From: dcplanning shared
Subject: FW: Comment on planning application

Ref. No: 21/03215/DOM |

My wife and I wish to make comments about the application to extend the house called Westfield that is directly south of our property.

Proposed Side Elevation at 1:100 scale
NORTH WEST

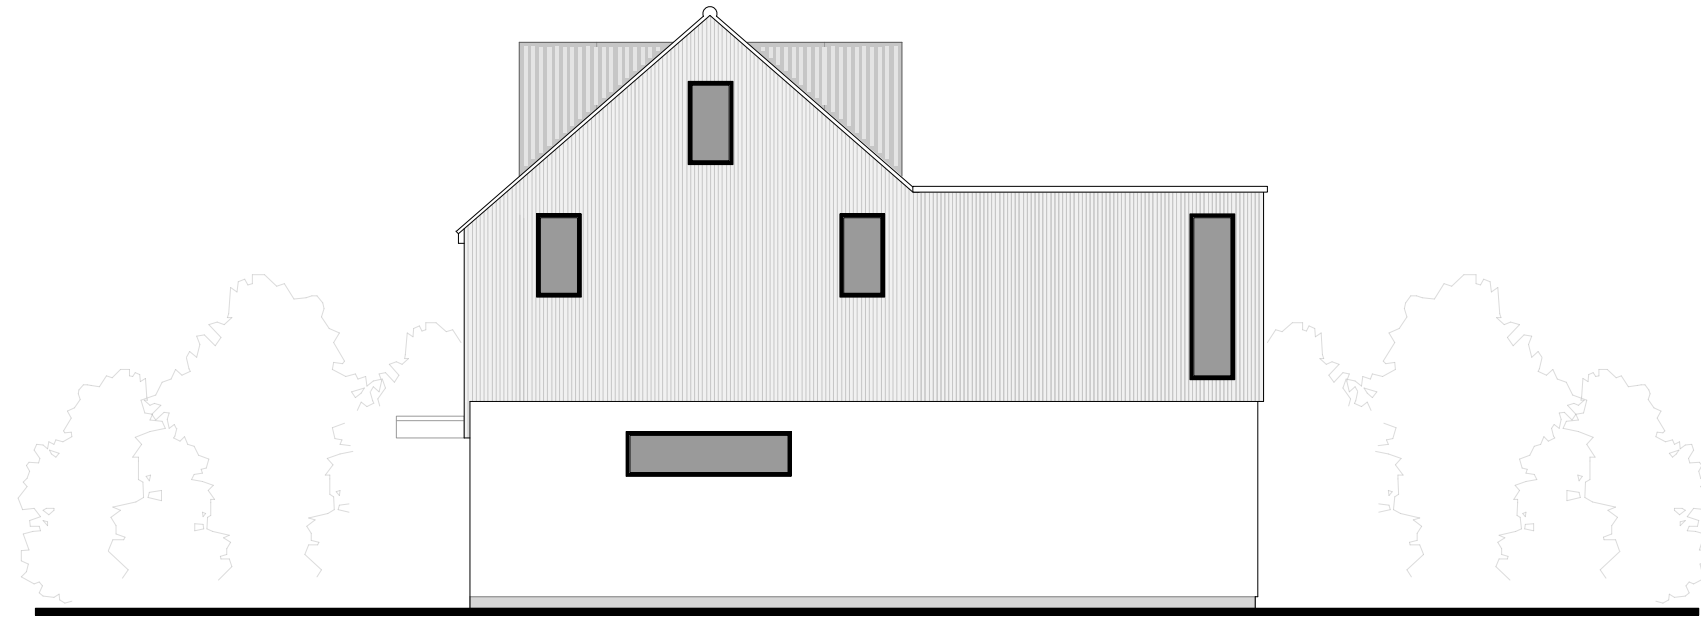
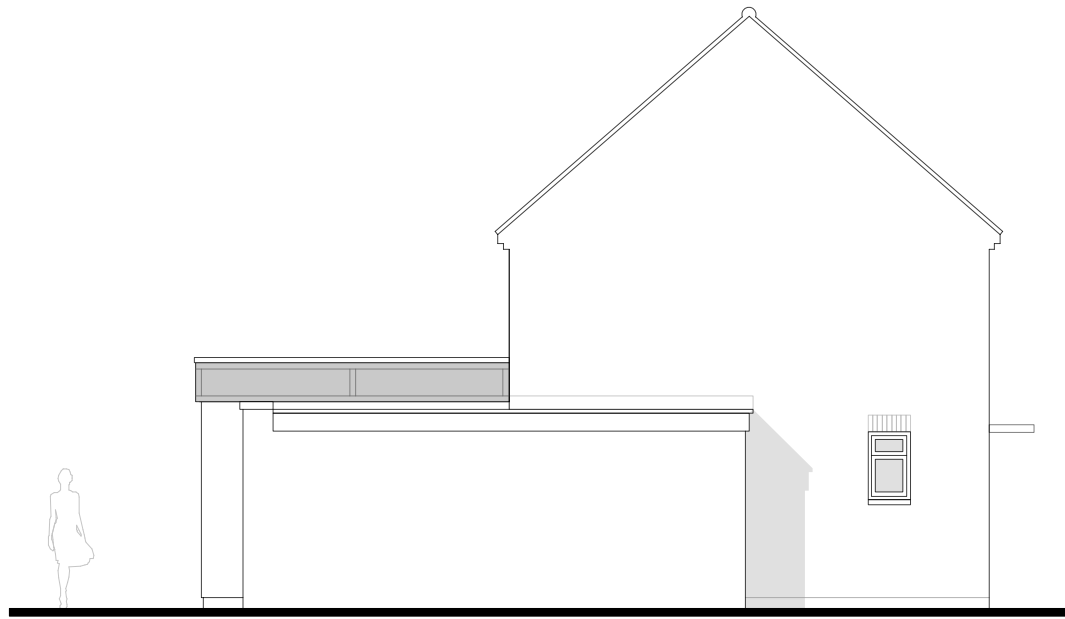
Our main problem is with the 1st floor window in the proposed bedroom 4. This window on the north side directly faces our property, and will be virtually opposite our main bedroom window that faces south. If allowed this would also give a clear view down into our lounge, kitchen, private courtyard and garden. We find this to be unacceptably intrusive and will remove all privacy.

Proposed First Floor Plan at 1:100 scale

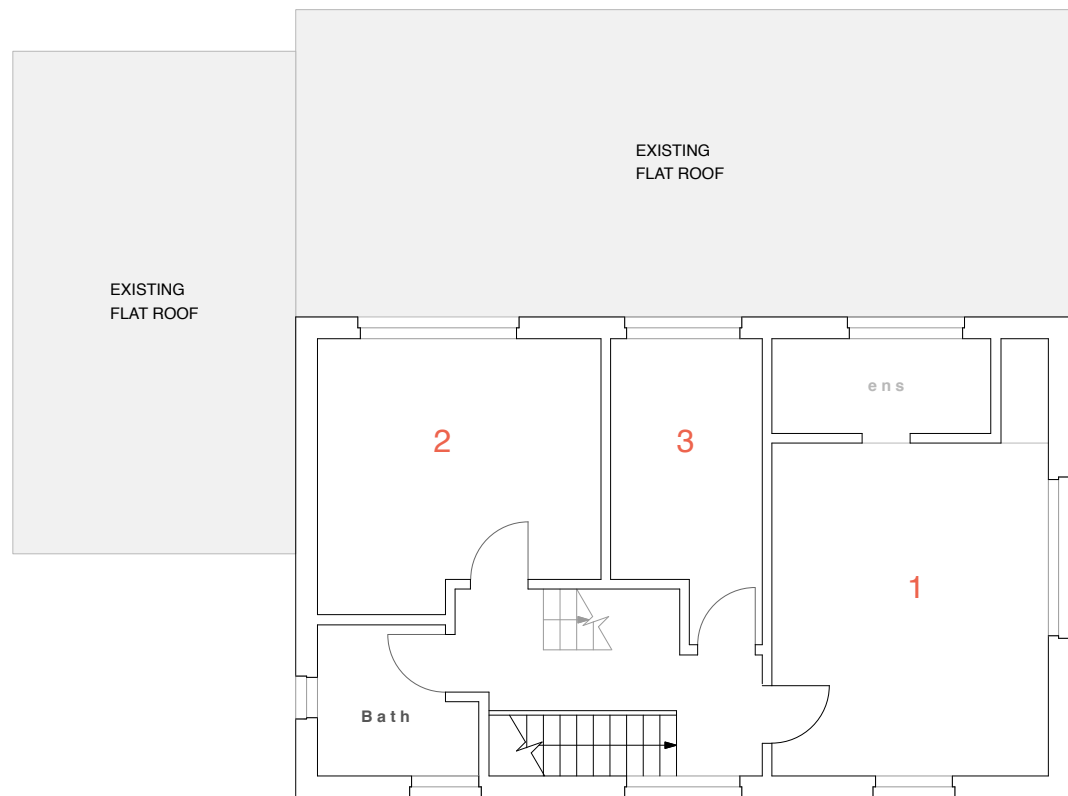
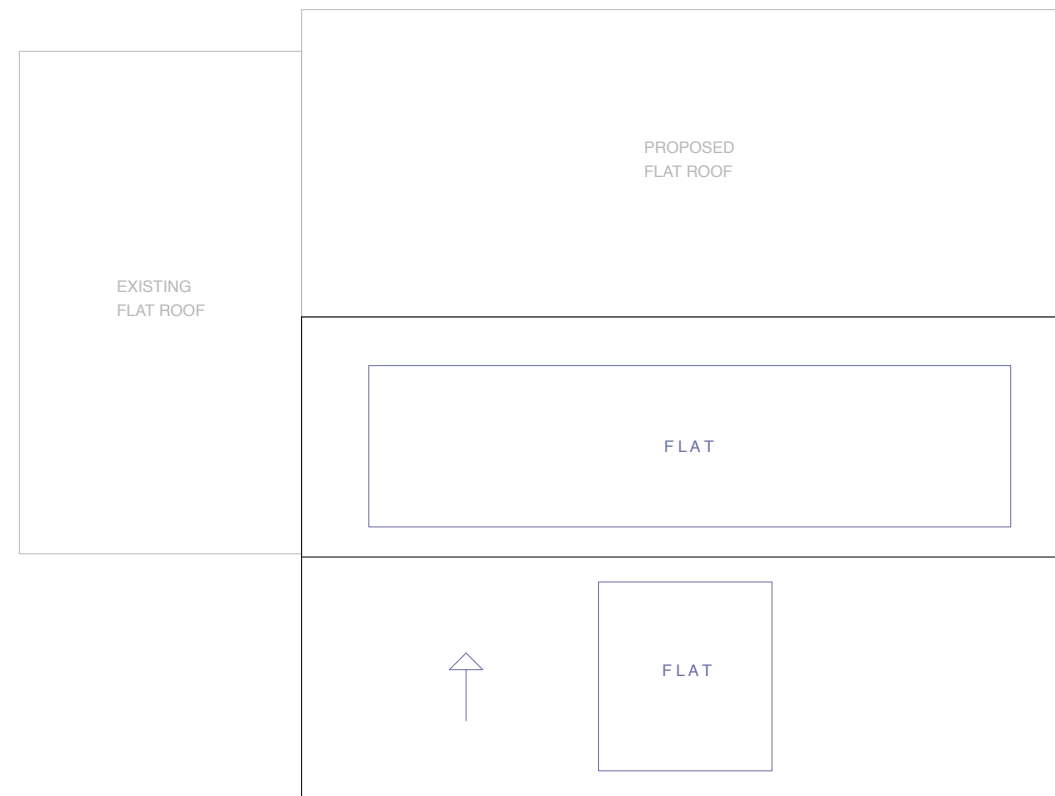
As it will overshadow and affect the light into our kitchen and lounge, we would rather that the 1st floor extension and the large 2nd floor dormer windows were not built, and think that the size and design is visually out of keeping with the rest of the buildings in the area.

We have discussed this with Harvey and Charlotte Hillary and they are aware of our views and have said that they can accommodate the removal of this window.
